Subject: Huntingwood Processing expansion – 65 Huntingwood Drive, Huntingwood (SSD-17352813)

Thank you for your email received 19 October 2021 requesting comments on the Environmental Impact Statement (EIS) for the subject proposal. Environment, Energy and Science Group (EES) has undertaken a review of the EIS and related information and provides the following comments.

Drawing Name:
Landscape Plan

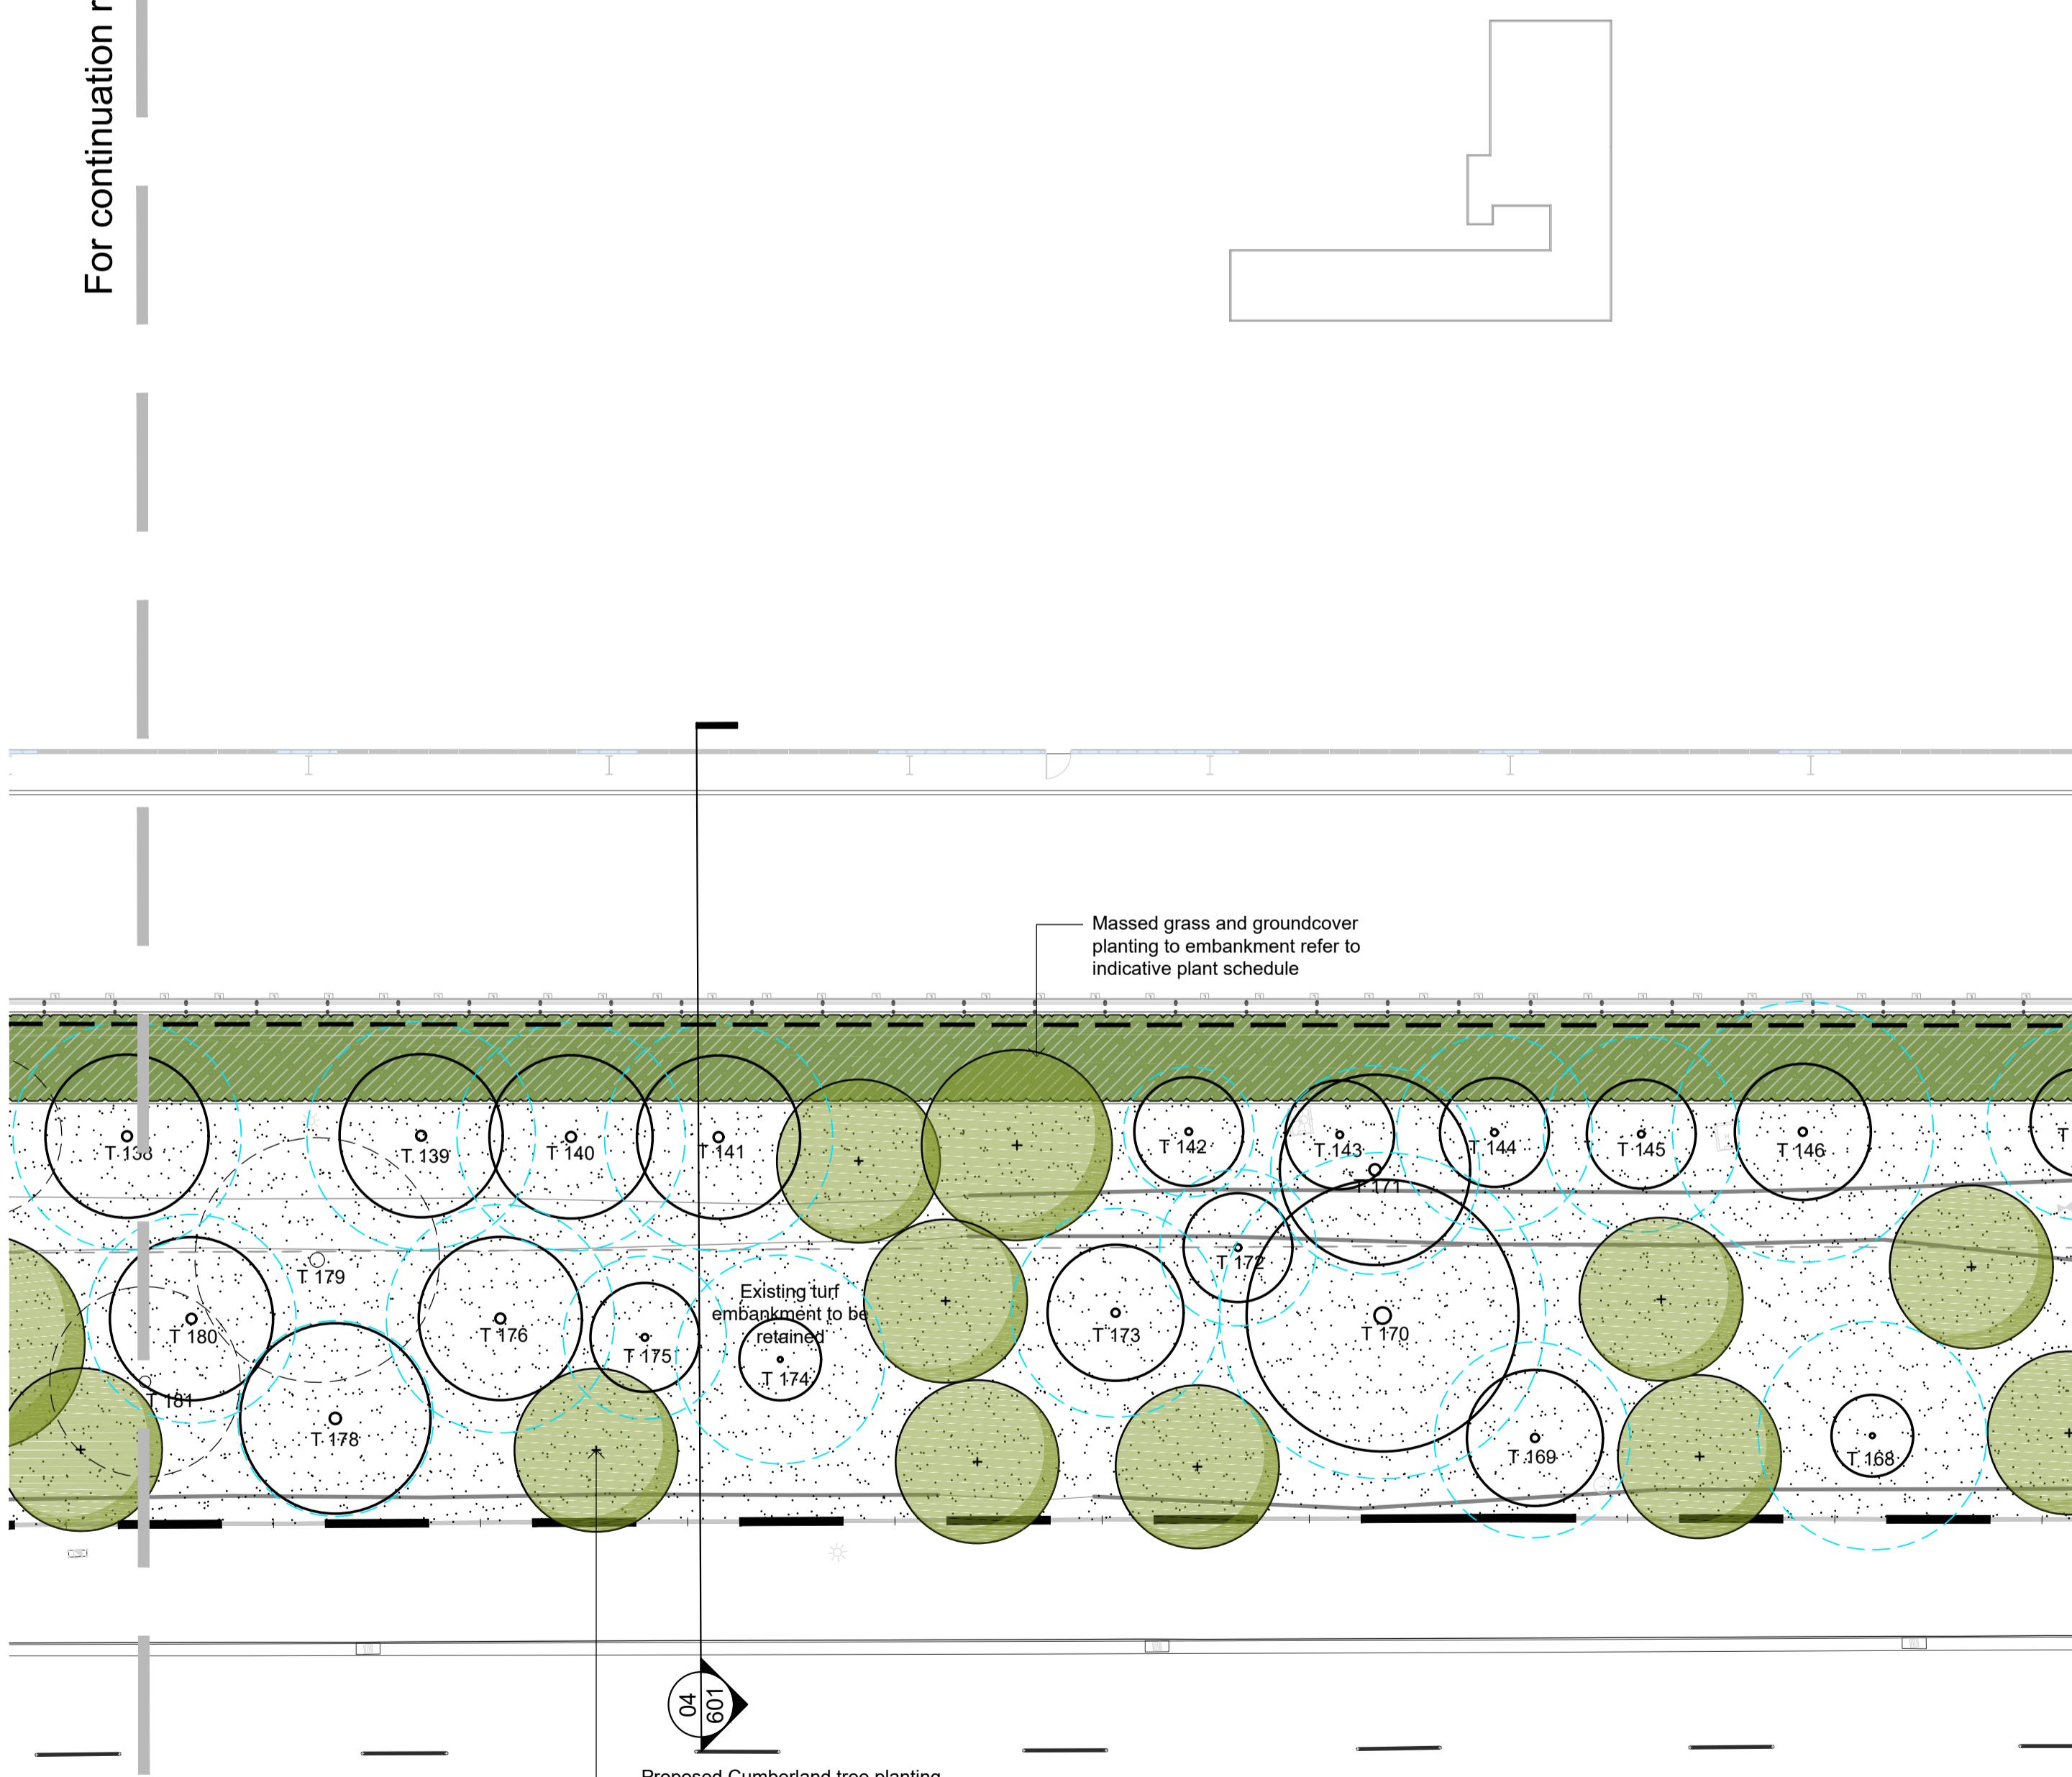
Application of the avoid, minimise and offset hierarchy must still be demonstrated for the proposed development and EES notes that of the 342 trees assessed for the proposed development, 272 are proposed for removal. The proposed landscape plan identifies a total of 256 replacement trees to be planted on site.

To further minimise impacts, the proposed landscape plan should be amended to incorporate additional canopy tree planting. Opportunity for additional planting may exist within the eastern and southern boundary setbacks. An overall increase in the number canopy trees is preferred however at minimum a replacement ratio of 1:1 should be achieved.

EES also notes that the planting schedule included in the landscape plan fails to specify the number of each tree species to be planted. This detail should be provided to demonstrate a suitable level of species diversity in the proposed landscaping.

Further to the above, EES recommends that landscaping of the site uses a diverse mix of local provenance native species from the native vegetation communities that occur, or once occurred on the site (Cumberland Plain Woodland) rather than using exotic species or non-local native species. EES notes that several of the shrubs, grasses and groundcover species in the 'indicative planting schedule' in the Landscape Plans are not consistent with species found within Cumberland Plain Woodland.
